**Planning Application Ref:** BN/84/20/PL

**Location:** Land at Angels Nursery, Yapton Road, Barnham, PO22 0AY

**Description of works:** Application for variation of condition 2 (approved plans) imposed on planning permission BN/93/19/PL for the development of 95 dwellings; and consequential changes to other conditions following commencement of development.

SITE LAYOUT P19-0723_10P

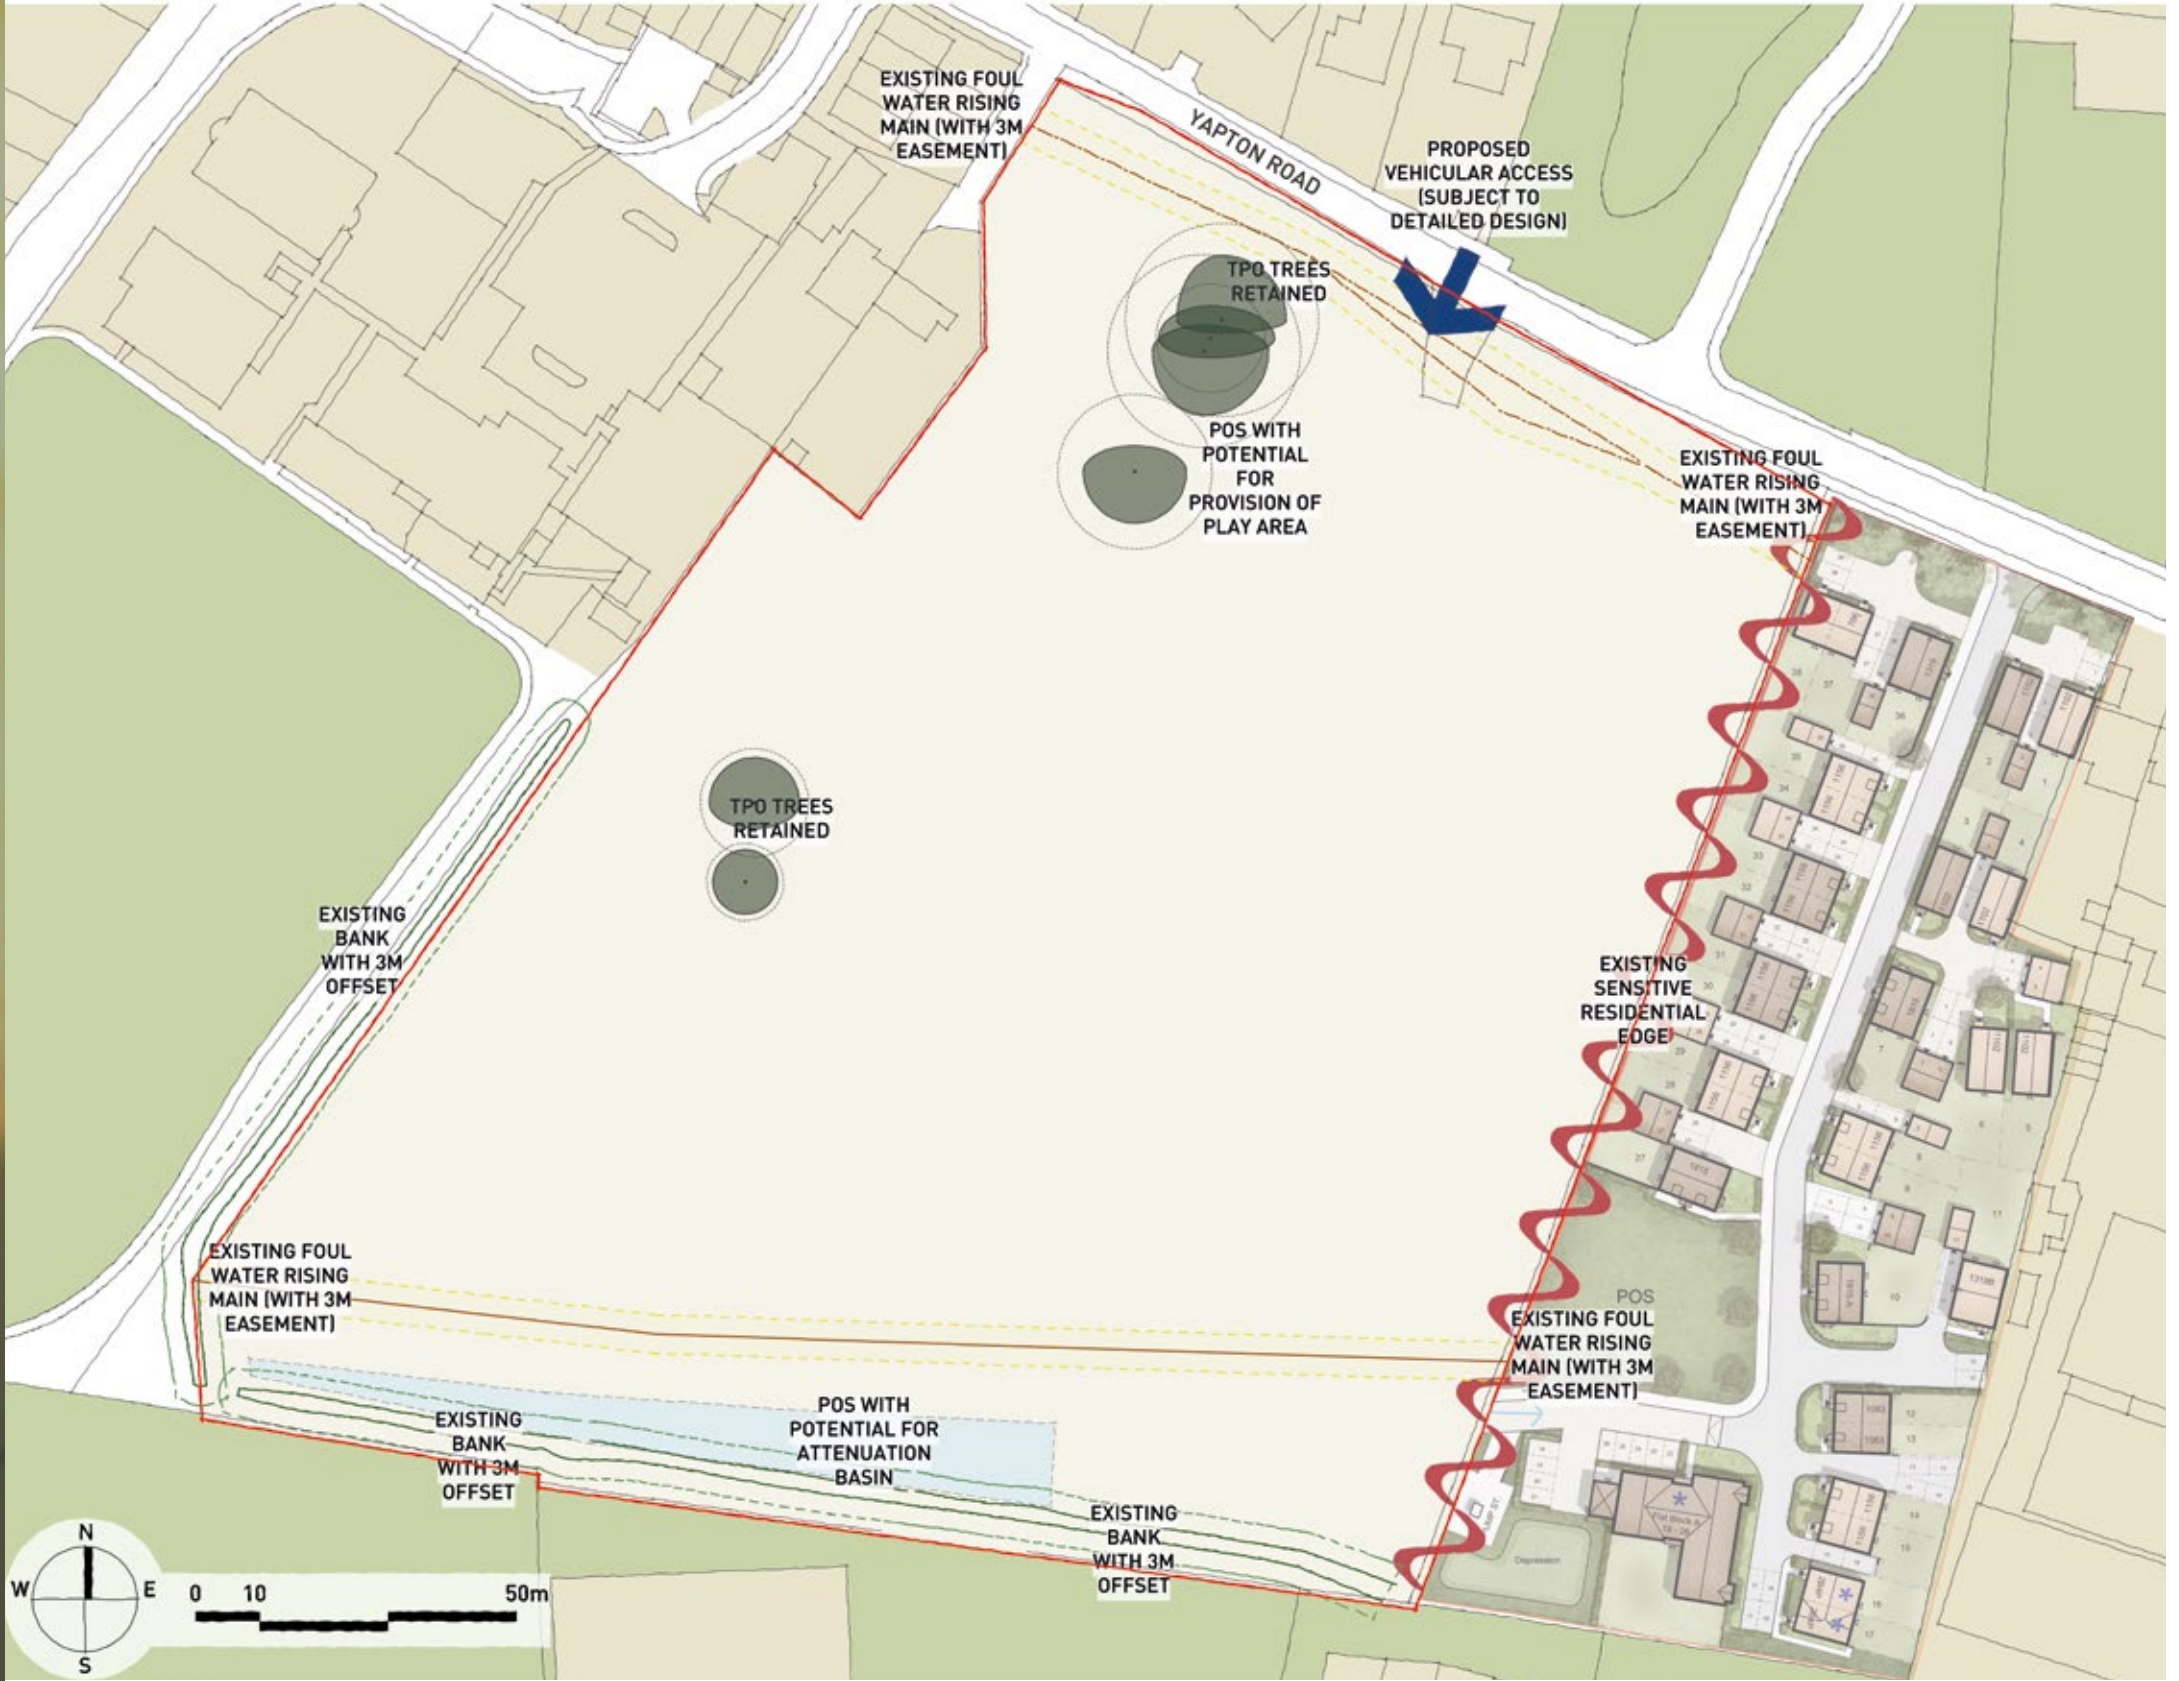
- Site layout P19-0723-10 Rev P
- As a general principle of design, careful consideration should be given to the intended land use beneath existing canopy of established trees and the potential for further tree growth. With such a large and open site to work with I would expect a layout proposal to have placed great emphasis on eliminating future 'pressure to prune' of retained trees. Furthermore, there would need to be a compelling argument in favour of any Root Protection Area (RPA) incursion as this site clearly lends itself to a harmonious design that avoids any direct interference with established trees of current and future landscape value. This is especially relevant where there are relatively few established trees of moderate-high quality, as is the case here.

- In respect of Site layout P19-0723-10 Rev P, I make the following comments:
  - Our drainage engineer makes reference to a proposal for the infilling of a watercourse. I was not able to retrieve that information for myself so am not able to assess its impact on any retained trees, but I would like to draw attention to the potential for significant harm to trees in general where the soil level is raised or lowered over the rooting area. It is hard for me to imagine a scenario where the infill of an established watercourse cannot be avoided with a sympathetic and imaginative design.

- The intrusion into the RPA of T64 oak and T65 oak (both TPO) is both unsatisfactory and avoidable. These trees need to be given plenty of room to develop into late-maturity without coming under pressure to prune or remove.

- The group of T85-T87 incl. poplar (TPO) are a management concern post-development being so close to residential dwellings. The proposal of play areas in and about the crown spread of those trees is ill-advised from a safety perspective as well as curtailing their growth potential.

- There will need to be careful analysis of soil type when considering appropriate foundation type/depth for built structures within potential distance of influence as well as provision of no-dig construction within RPA's. It may be desirable to avoid such costly mitigation and future risk management with a more evasive design, perhaps extending the area of open space west of the tree-line.

- As it stands, I am unable to lend this scheme my support and so register an **OBJECTION**.
- The applicants will need to employ the services of an Arboricultural Consultant to submit an Arboricultural Method Statement (AMS) and also a revised Tree Protection Plan – to both describe and illustrate the mitigation measures which are to be employed to ensure that the trees survive without detriment to their vigour and vitality and are given adequate protection both above and below ground.
